From: Simon Davis
Sent: 25 February 2019 13:00
To: Planning.Responses
Cc: Laura Gibbons
Subject: FW: Planning Consultation on: BE/137/18/PL
Attachments: C14443-215 - C1 Proposed Drainage Layou.pdf; 60579154-SHT-00-0000-C-00002.pdf

Engineers Comments Regarding Surface Water Drainage

Proposed Site Layout Plan

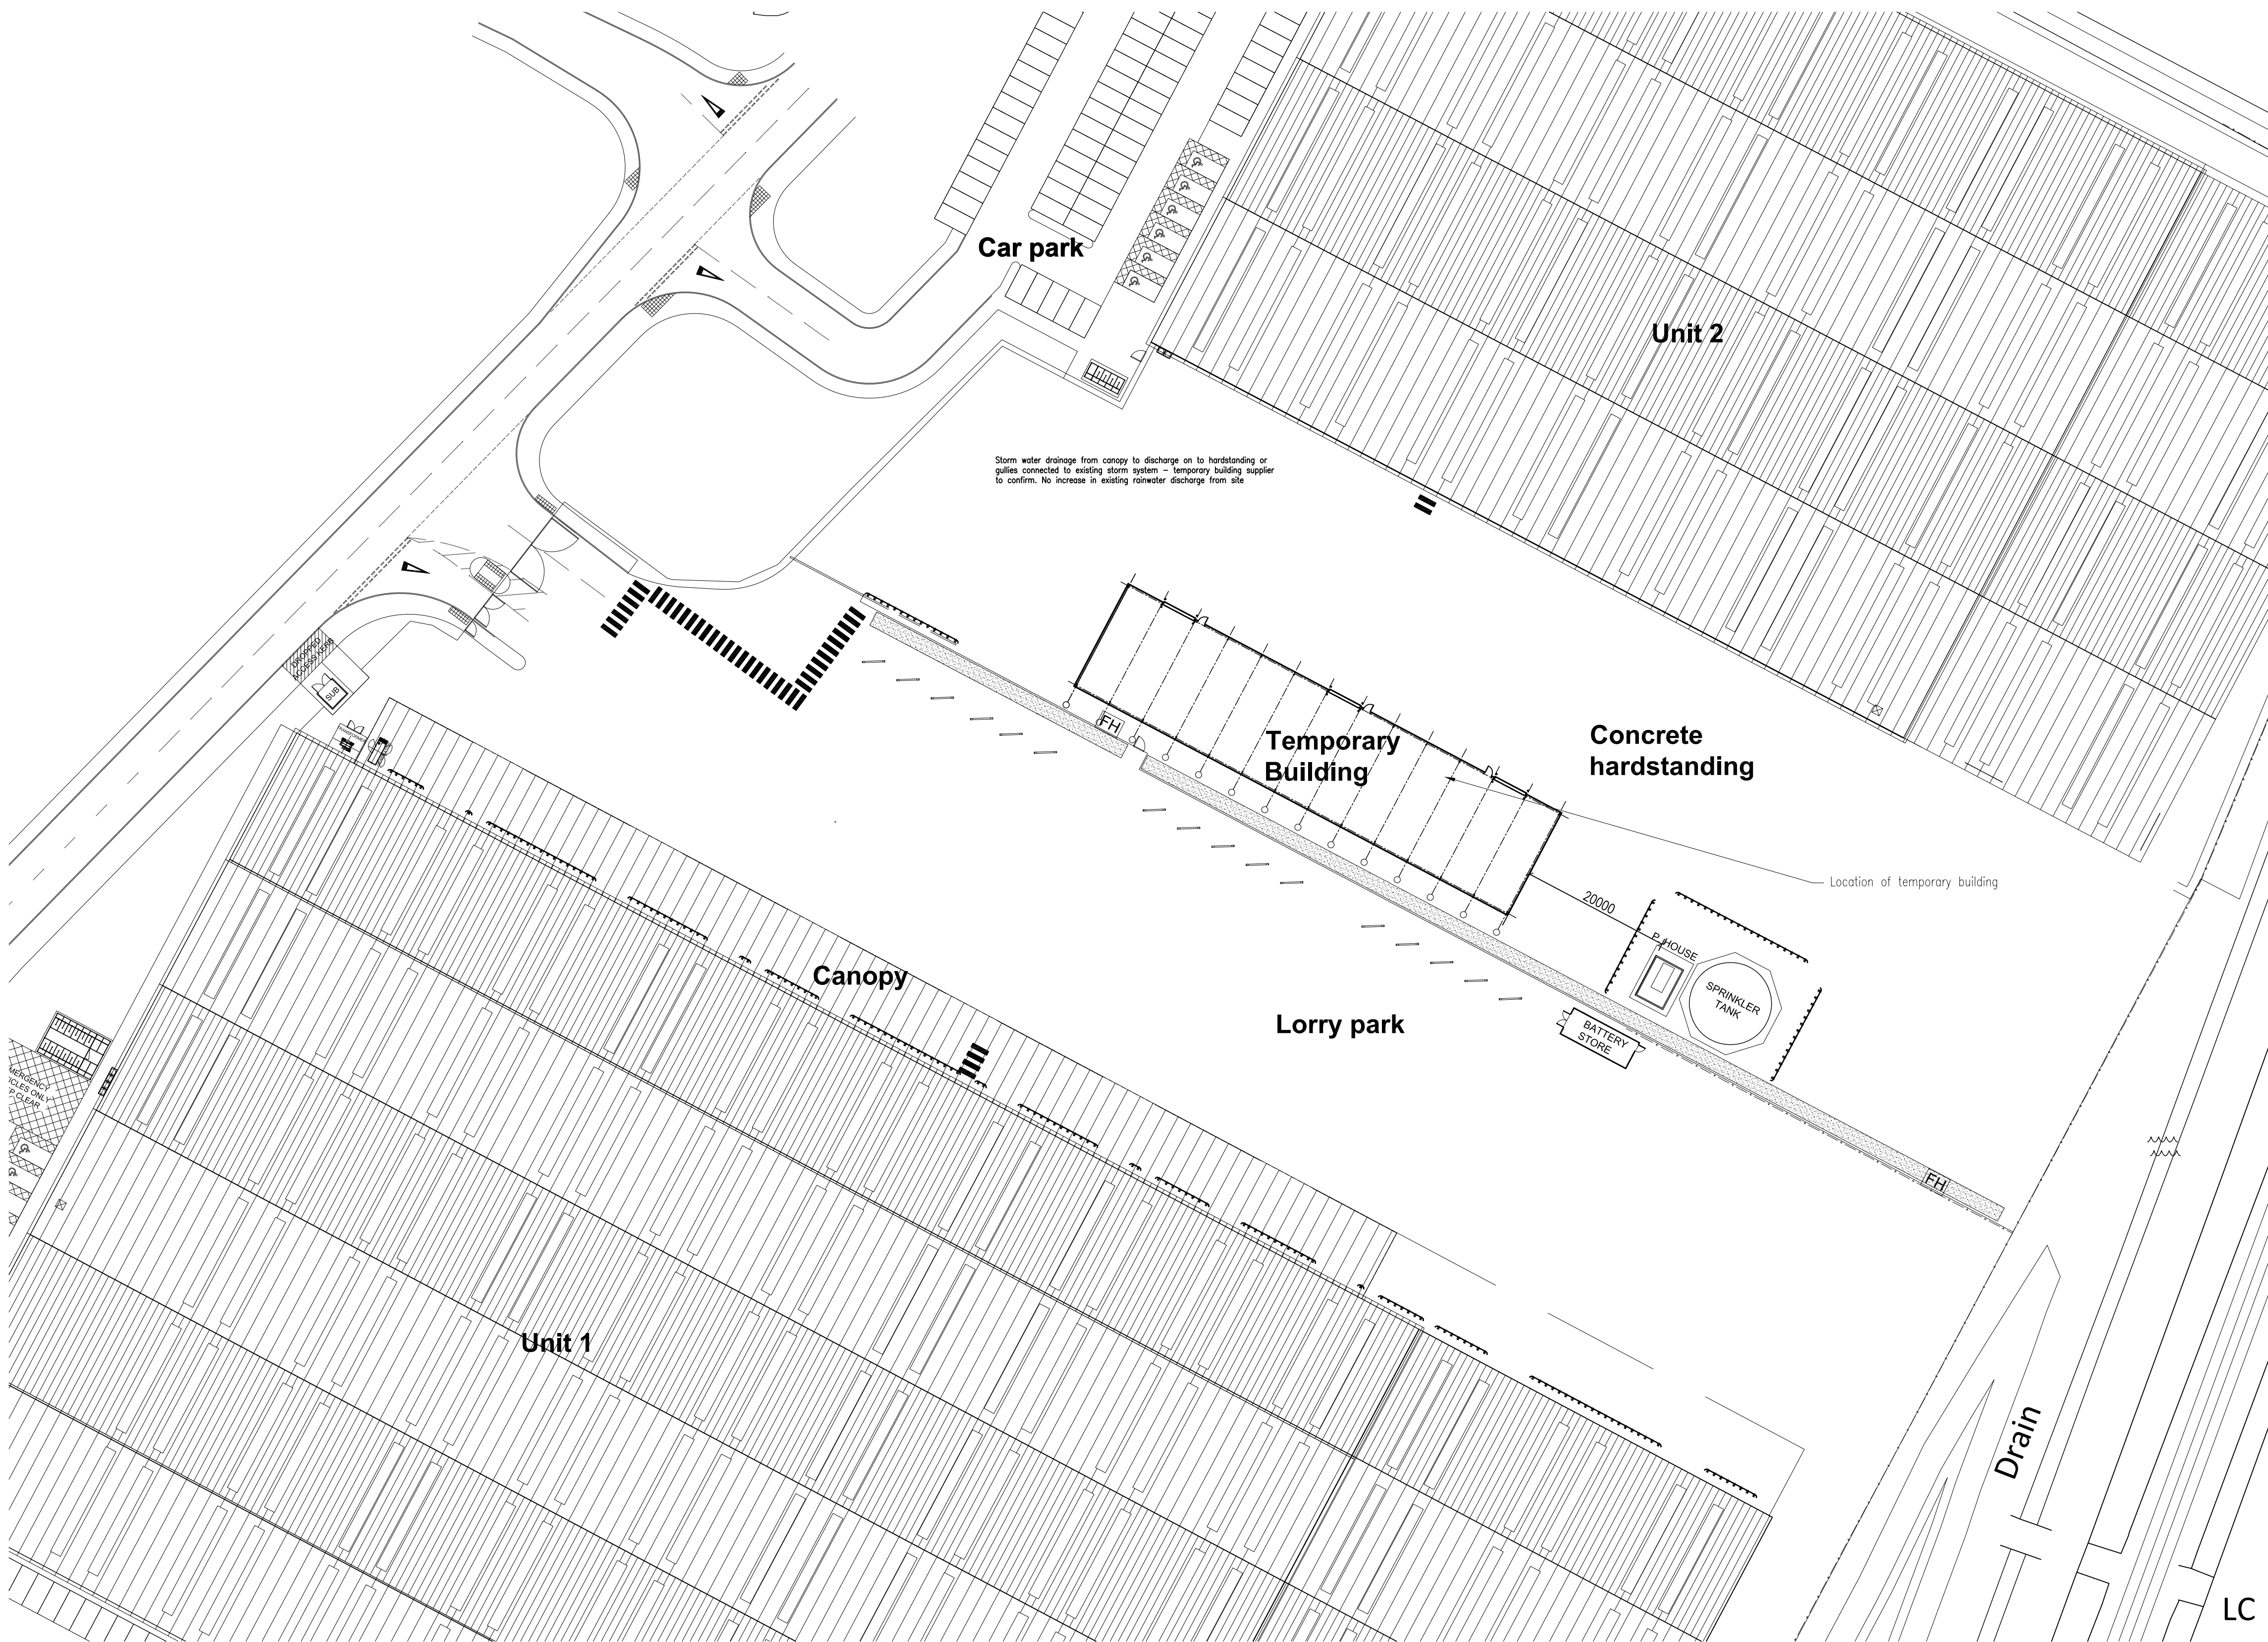
We require confirmation that the proposed temporary structure will not be located directly on top of the existing surface water drainage network. Please can the applicant provide as built survey of the surface water drainage network.

Thanks for coming back to me. Please find attached a copy of the Final Construction drawing for the SW drainage. The contractor (McLaren Group) have confirmed that this reflects the "as built" position of the surface water drainage.

We have also overlaid this drawing onto the layout plan (also attached) which demonstrates that there is no impact associated with the temporary structure. I trust that this confirmation is sufficient to enable a positive determination of the application. For the avoidance of doubt we have
